Our Ref: BE/29/18/HH
Your Ref:

Town & Country Planning Act 1990 (as amended)
Town & country Planning (Development Management Procedure) (England) Order 2015
Application for Planning Permission for Works or Extension to a Dwelling

Development First floor rear extension
Location 330 Chichester Road Bersted

DRW NO 3 SCALE 1/50
PROPOSED GROUND FLOOR PLAN

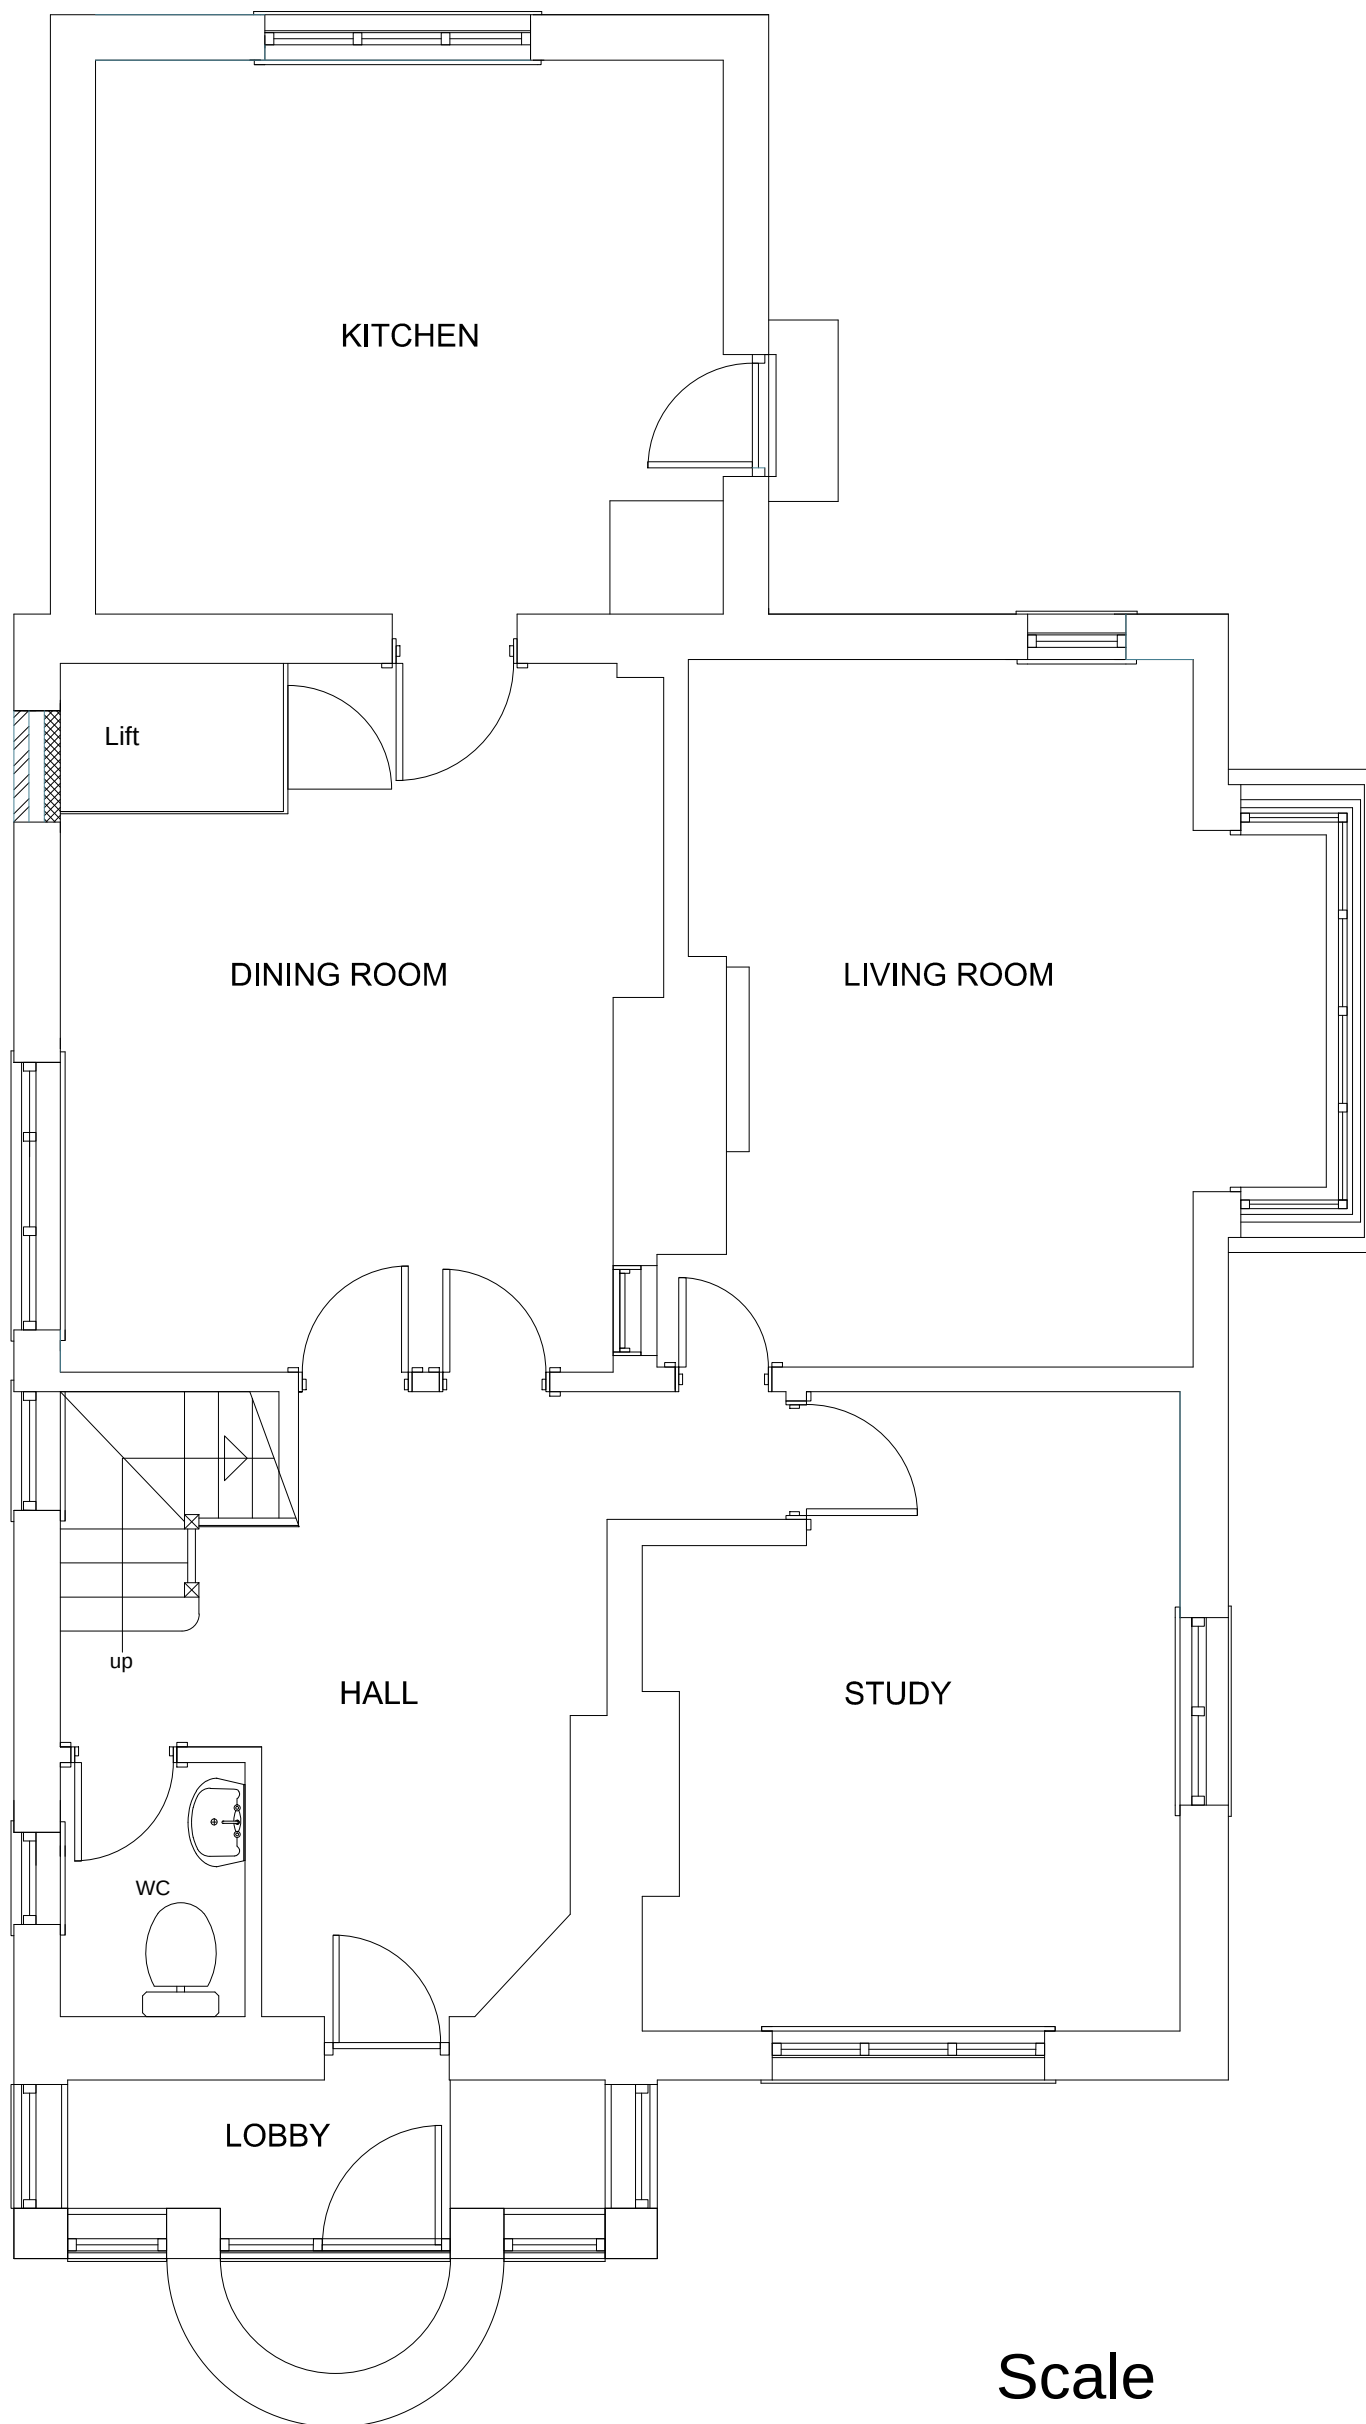
The proposed ground floor plan and north west elevation do not accord. Please amend accordingly.
